From: Jamie Brown [REDACTED]
Sent: 28 November 2019 10:19
To: Andrew Wood <Andrew.Wood@arun.gov.uk>
Subject: RE: A-132-19

It has been brought to our attention that certain elements of the sites Construction Management Plan have not been explained in sufficient detail. Whilst the commitment to provide wheel washing and on-site parking facilities is included within the Condition advised by the LHA in December 2016 there could be some further commitments provided by the applicant. On that basis could we please ask for further confirmation in the CMP on the following:

Rev	-	
Drawing Title		
Tree Protection Plan		
Client	Date	
GD Group	09.10.19	
Project	Drawing Ref	
Merry England	TPP	
Scale	Drawn	Job Number
1:250@A2	JLD	1909

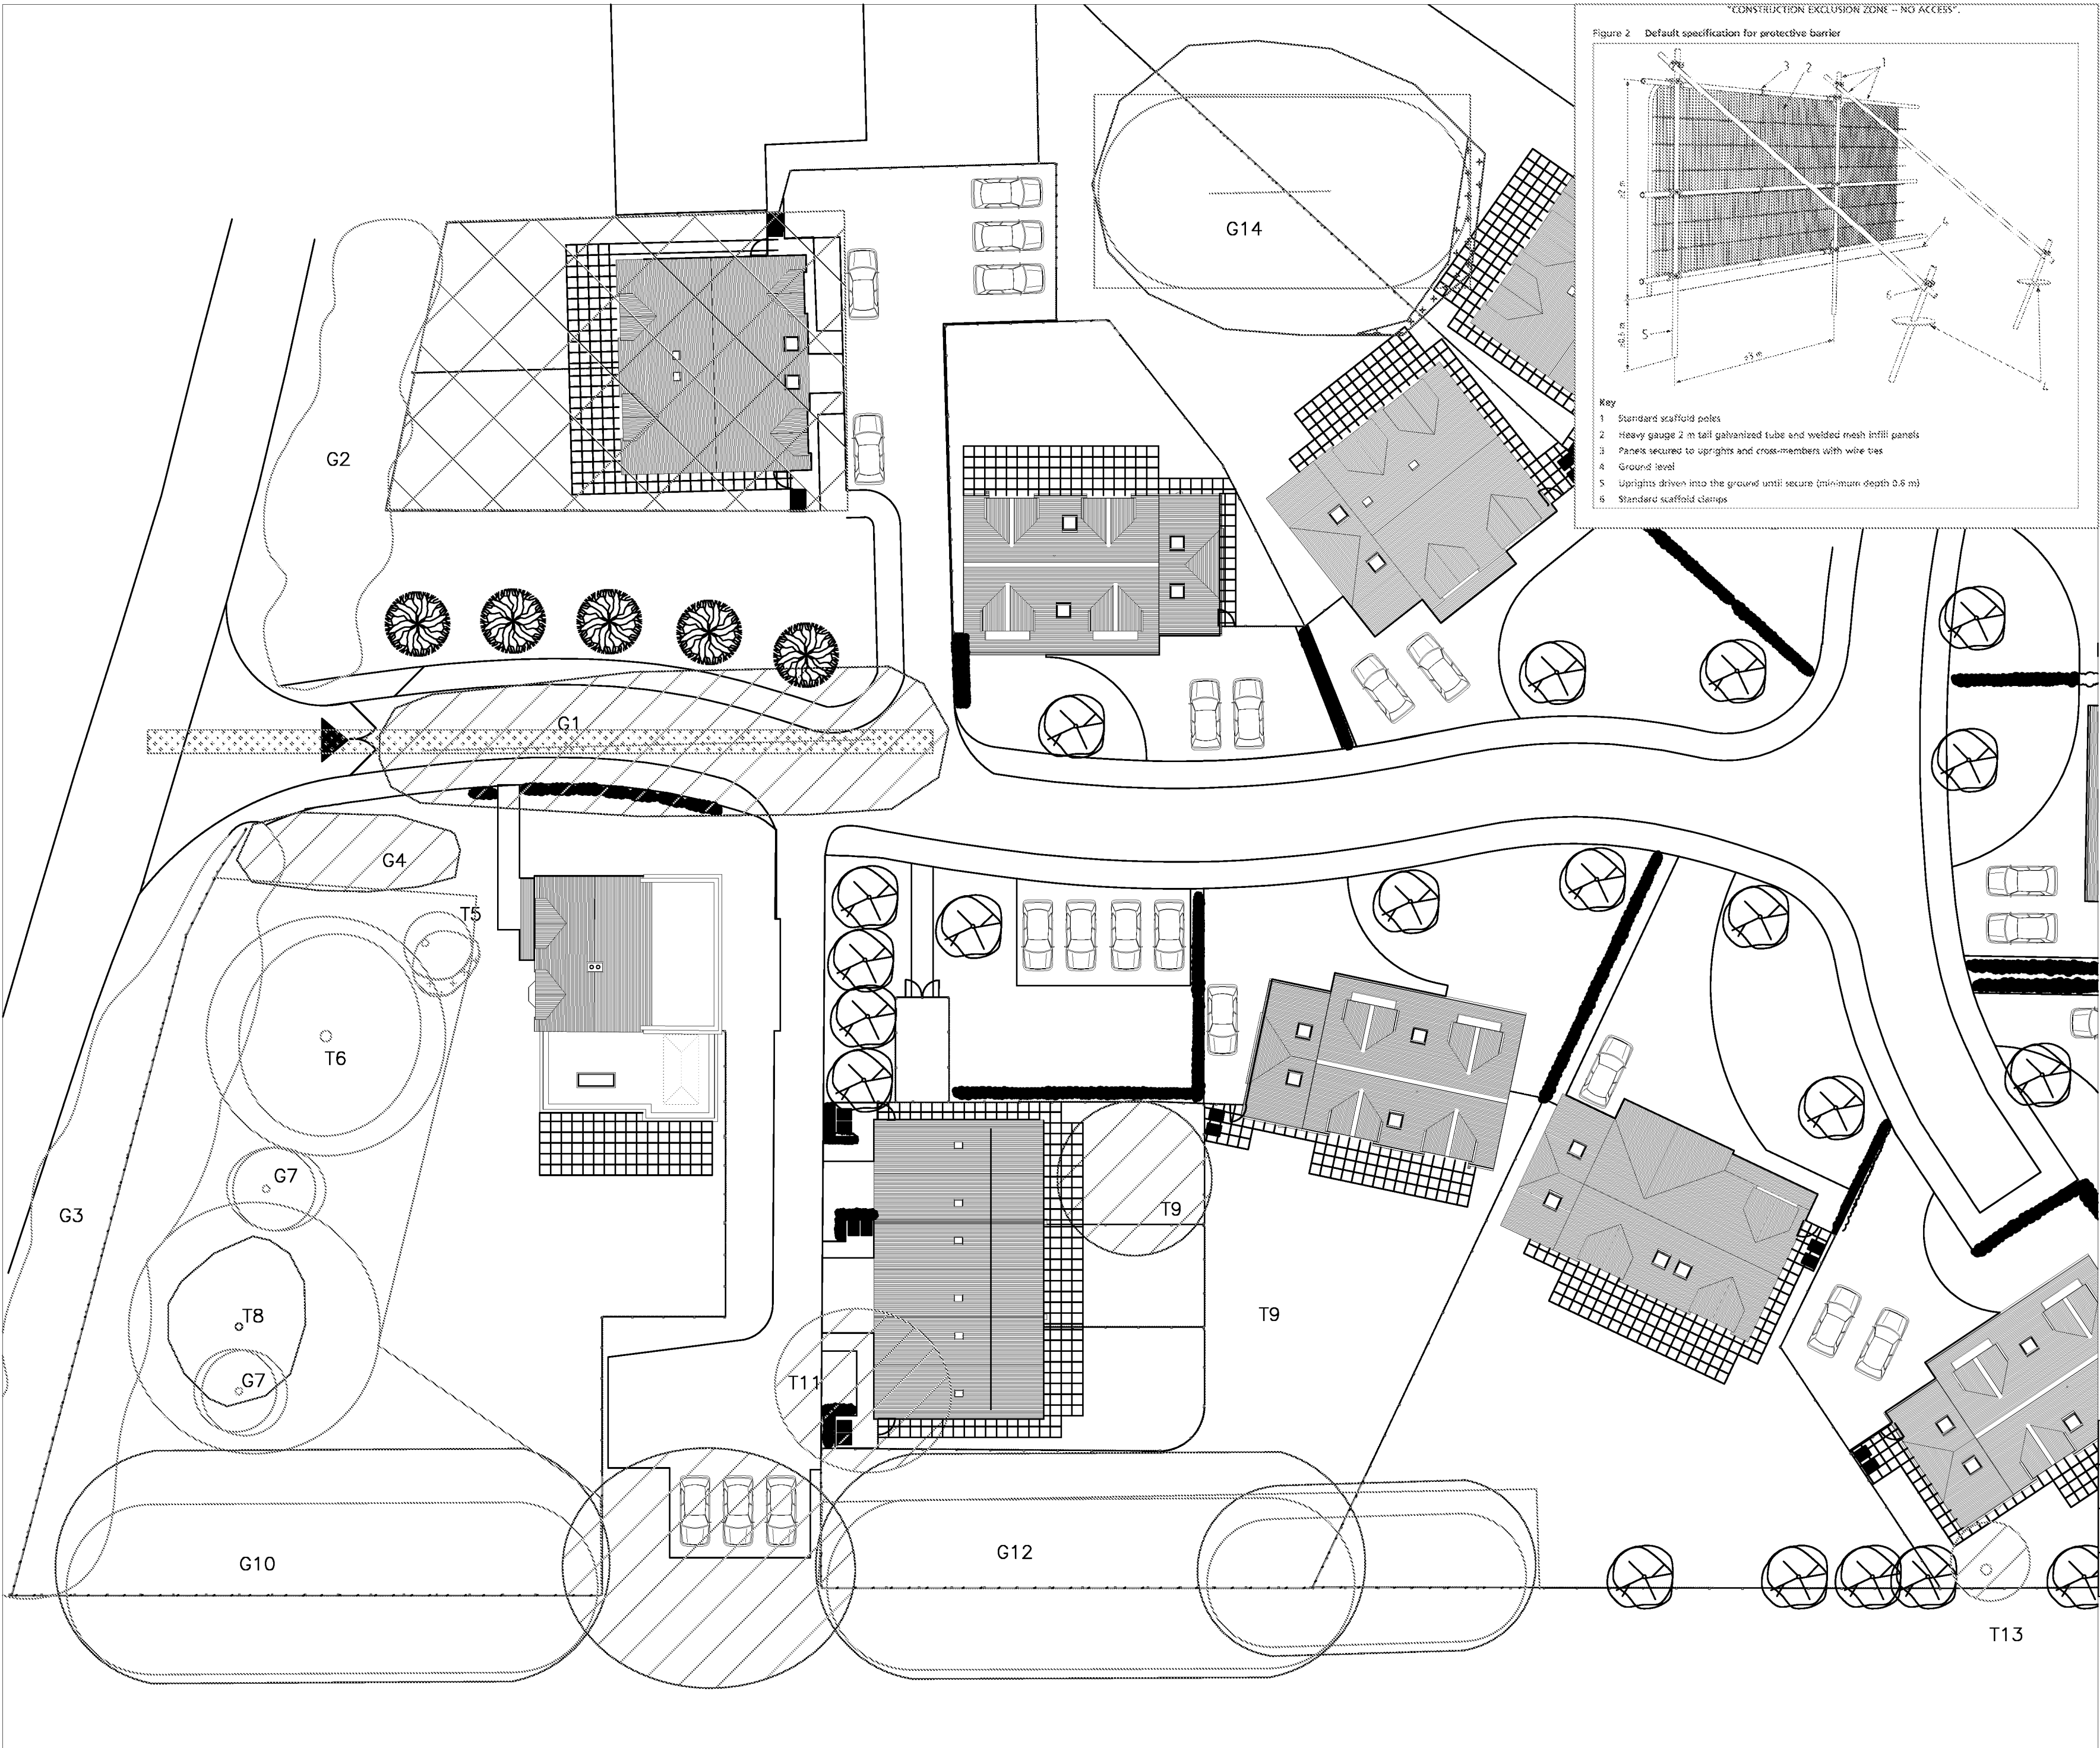
Thank you for the additional information. Wheel washing facilities have been confirmed which is all accepted. In terms of parking could they show a bit more clearly the parking areas (i.e. how many cars/contractor vehicles are likely to be in there) where an HGV is going to turn.

James is this diagram meant to show where contractors will be allowed to park on site? If so can it be labelled accordingly?

- Wheel wash facilities
- Parking and on-site turning requirements for site operatives and delivery vehicles

As requested I have adapted the layout and TMP accordingly. Changes made are:

- Introduction of clear turning circle and annotation.
- Annotation of number of vehicles in main parking.
- Introduction of overflow car park.

We have updated to state "site compound and parking" we have made the same amendment to the TMP also. If I can be of any further assistance please let me know.
